Land at Bilsham Road, Yapton
Planning Reference: Y/70/22/DOC

Approval of details reserved by condition imposed under ref Y/91/17/OUT relating to Condition Nos 9 - surface water drainage

At this stage we would not recommend that the condition is discharged until further information as outline below is resolved and provided:

Drawing No. D1956-15-3

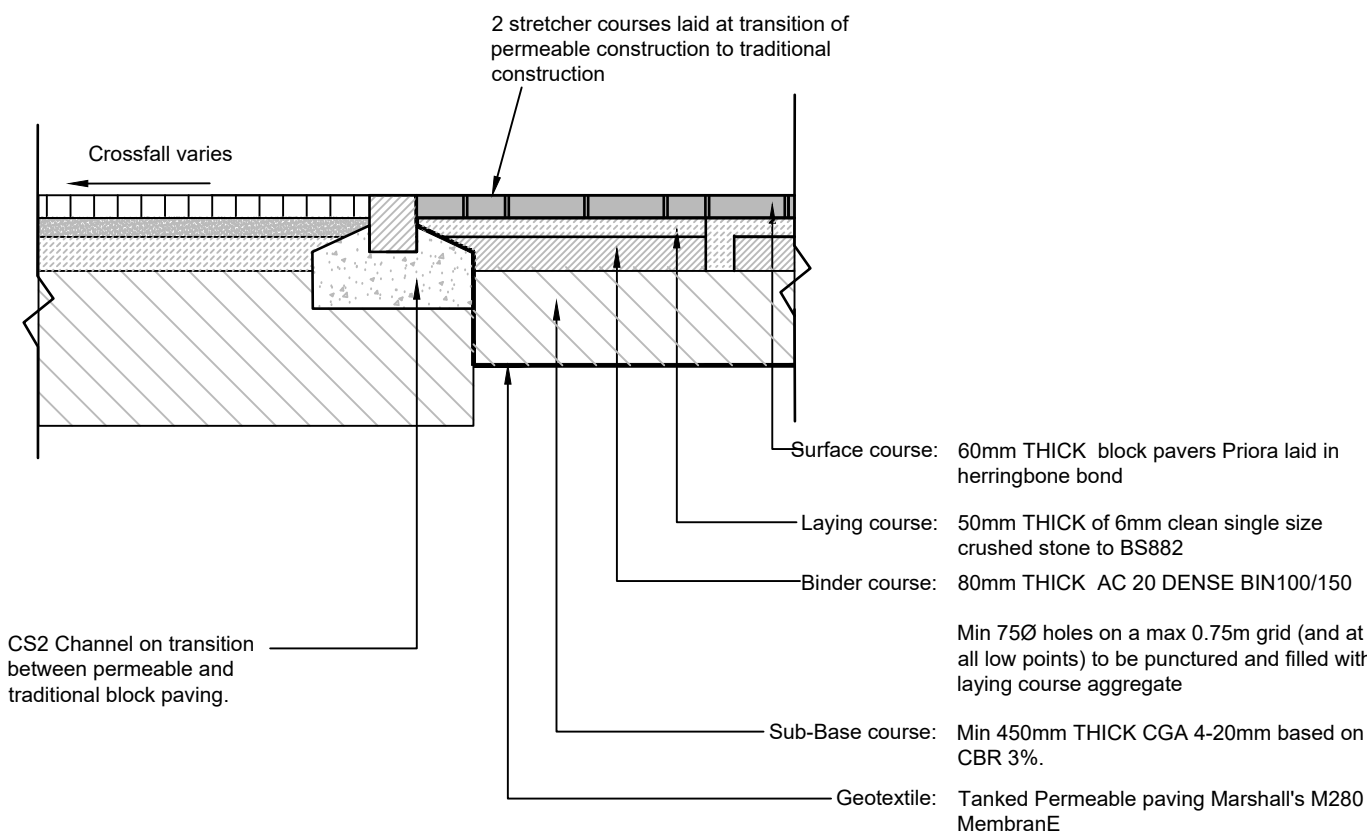
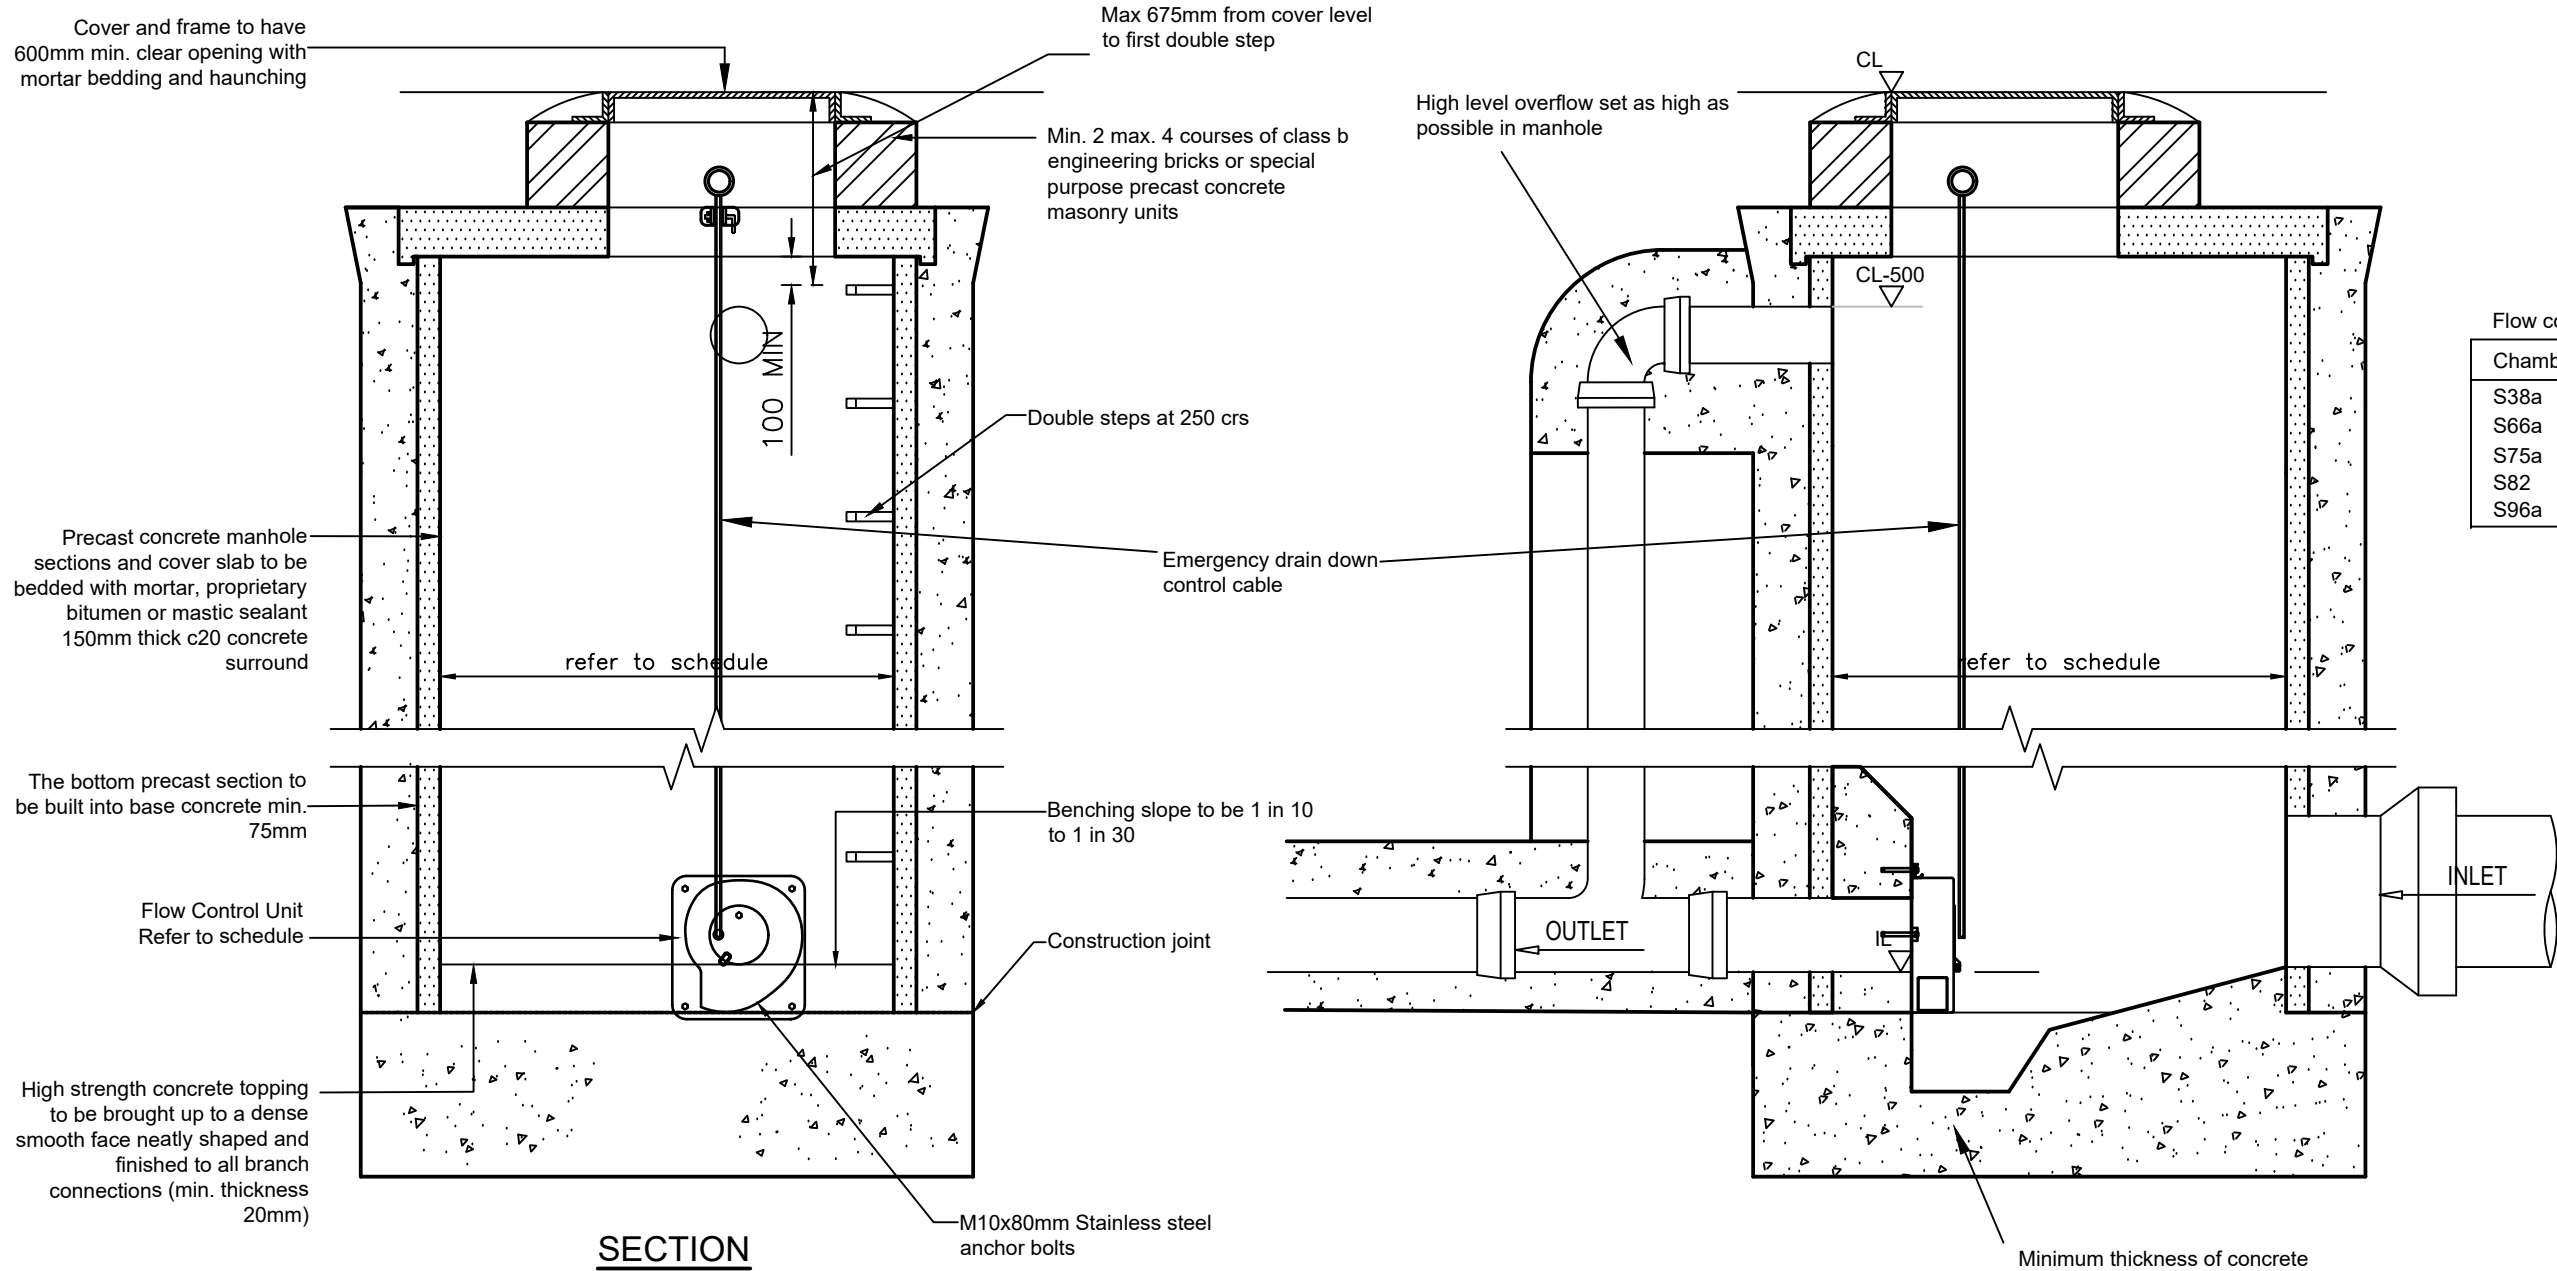
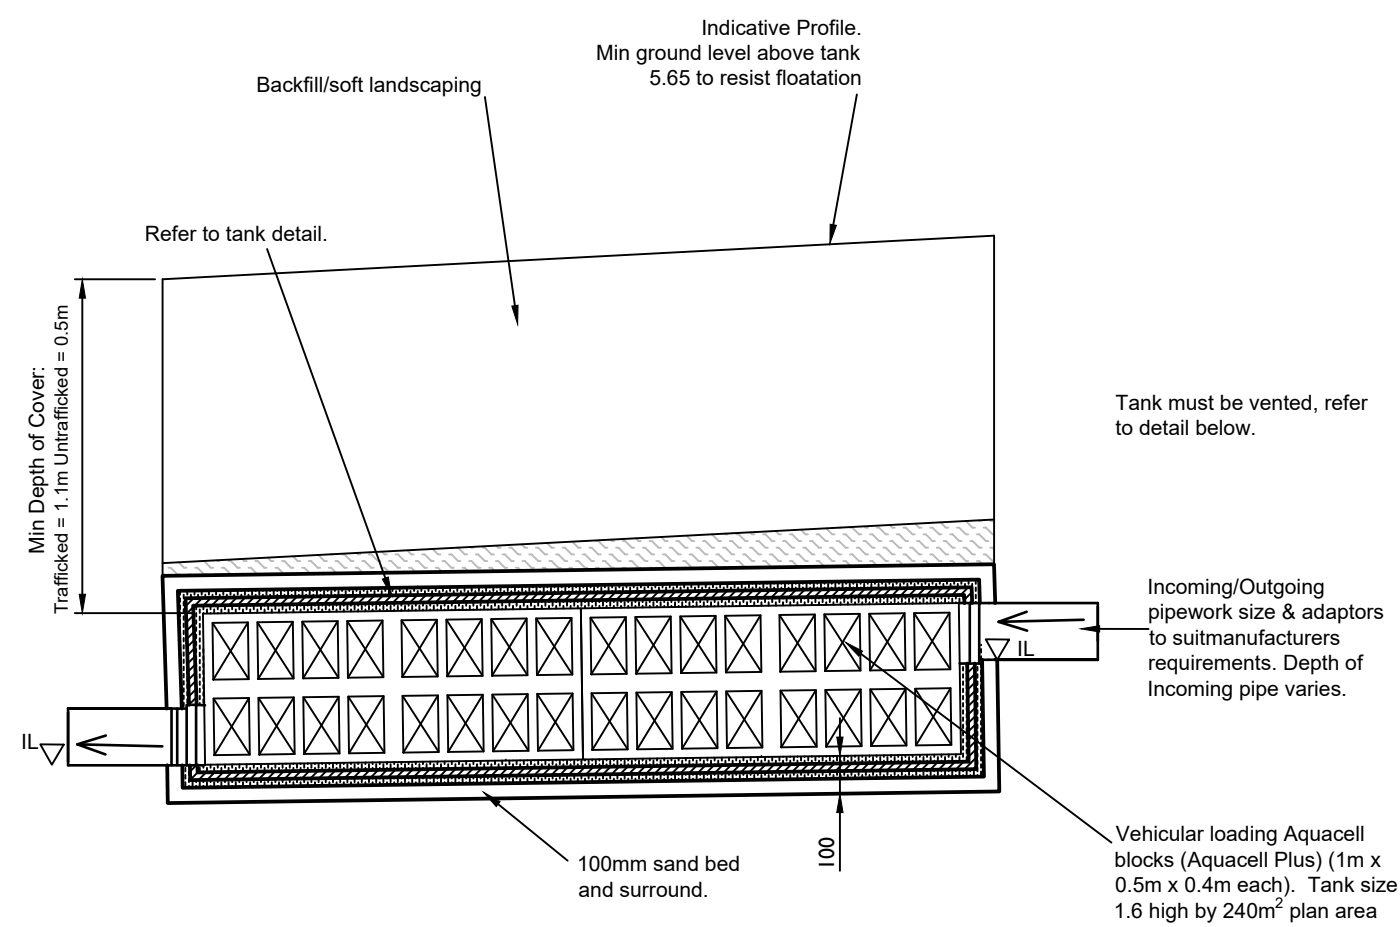
12. *Please detail invert levels of hydrobrakes and invert levels of overflows for each flow control device on the detail drawing.* –noted and accepted, but its note clear whether these hydrobrakes form part of the adoptable drainage network or not since they appear on the “private drainage” construction details. Applicant to confirm. It should also be noted that these some or all of these hydrobrakes may require updating to suit the correct greenfield run-off restriction

13. *There are inconsistencies between layout and details for the attenuation tank. Layout states a depth of tank of 1.5m but detail states a depth of 1.6m. Please ensure consistency.* The calculations still state 1.5m . Please also resubmit the construction details for this tank as part of this discharge application

16. *Please provide a construction detail of permeable paving which clearly defines the construction, i.e. blocks, bedding, membranes, sub-base, tanking membrane. Materials and depths should be clearly defined.* The construction detail shown on drawing D1956-15.2 conflicts with that shown on D1956-15-3A. These need to be updated to ensure there is no conflicting information. In addition to this its not clear why part infiltration has not been sought in areas where the infiltration has demonstrated that this is achievable. The applicant should clarify clear reasons as to why infiltration techniques have not been used for the permeable paving in the areas within the vicinity of the following test locations: TP05; TP04; TP01.
